Planning Application Ref: AW/20/17/DOC

Location: Countisbury Lodge, 7 Countisbury Close, Aldwick

Description of works: Condition 10 – AMS report & mitigation measures must be submitted and approved in writing prior to commencement out on site.

DRAWING	BR 014 Method Statement Site Plan		
DATE	10 01 17		
AUTHOR	AH	REVISION	CORINTHIAN ARCHITECTURAL DESIGN 8 Davys Court, Funtington, Chichester, West Sussex. PO18 9LG 01243 576 078 > contact@corinthianad.co.uk > www.corinthianad.co.uk
STATUS	DRAFT BR		
SCALE	1: 200 @ A3

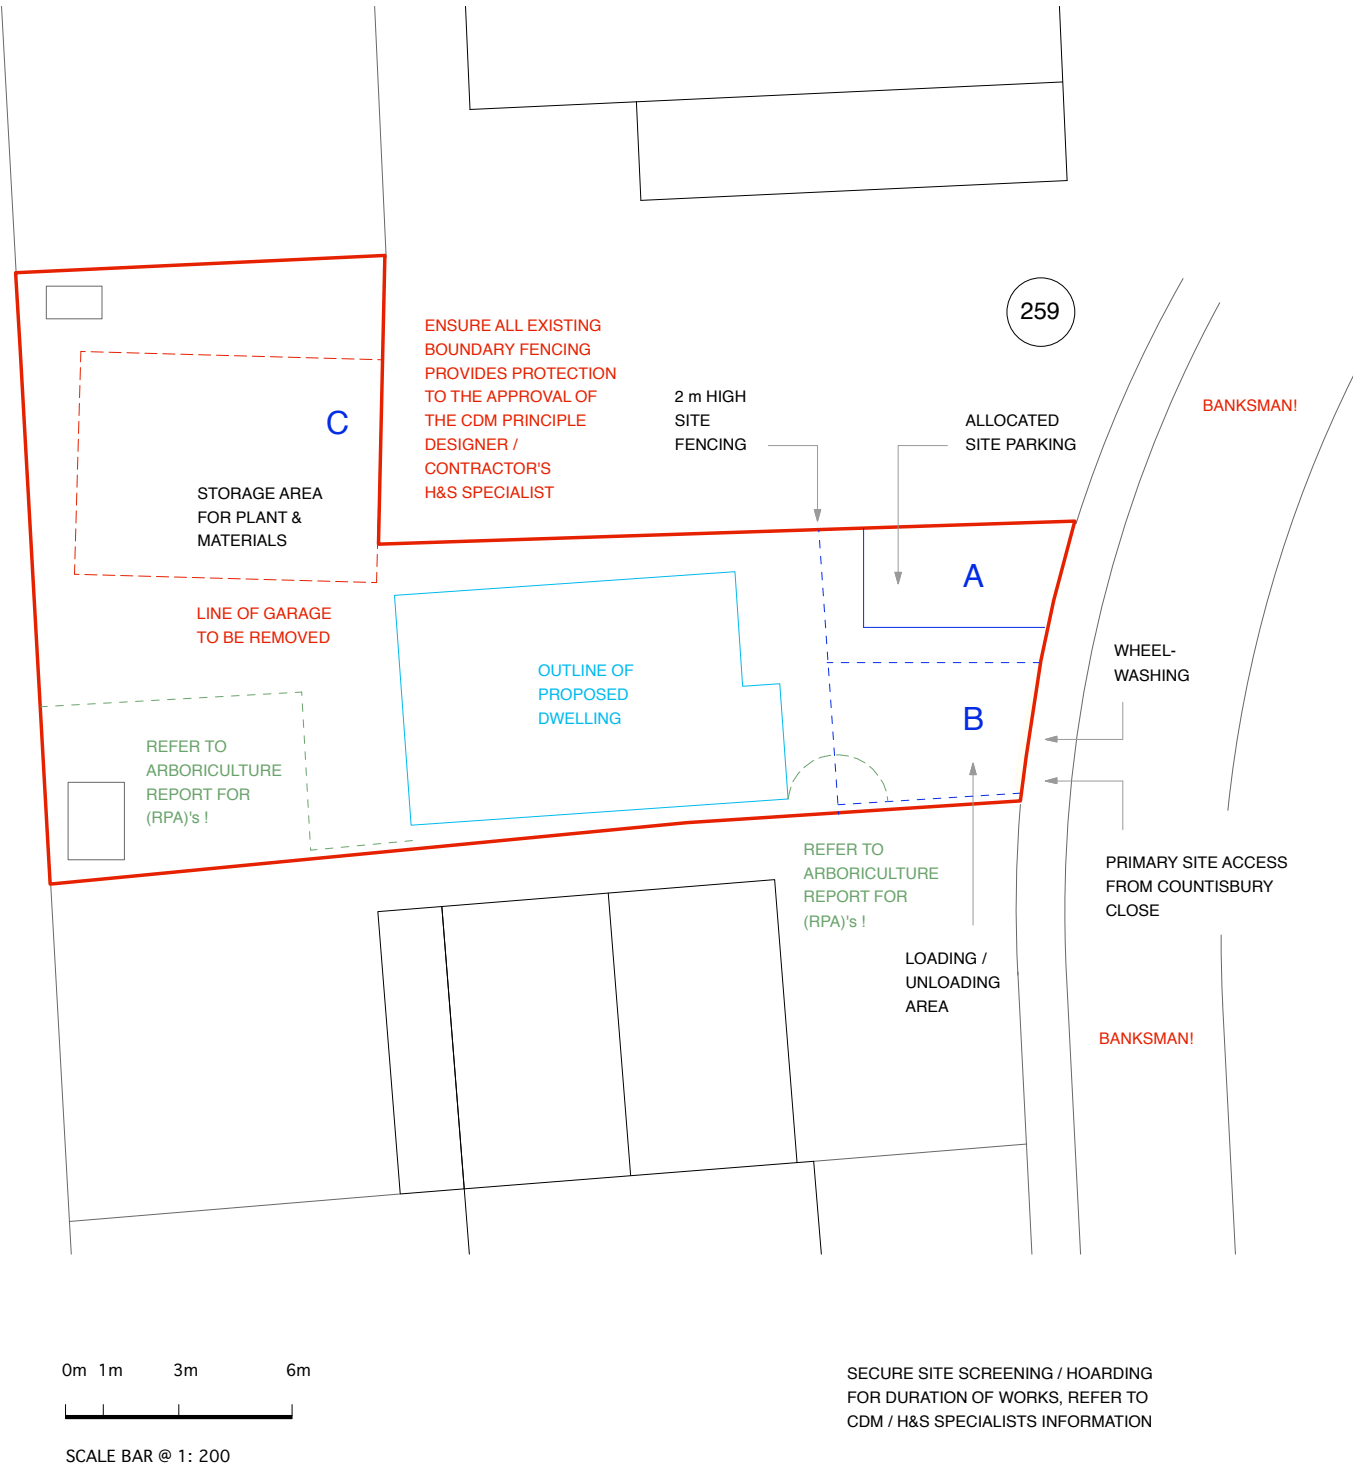
- Condition 10 requires that no construction works shall be carried out until the AMS report & mitigation measures must be submitted and approved in writing.
- This project has not only been commenced but almost completed.
- I saw no protective fencing in place out on site and scaffolding is erected where the fencing should be at the front of site.
- Dafydd wrote on 26th June 2016 that the applicant has failed to provide any reports relating to the protection of trees potentially affected by the proposals.
- As far as I can see the AMS tree report was apparently written on 7th July 2016 and the Conditioned approval granted on 14th July 2016.

- I am only able to comment on the data that has been provided to me – it is possible that I am not party to all that has taken place on this project.
- Protective fencing has not been erected to protect the off-site trees which are to be retained.
- I am therefore unable to sign off on Condition 10 and it is possible that there has been a breach of a Planning Condition here.
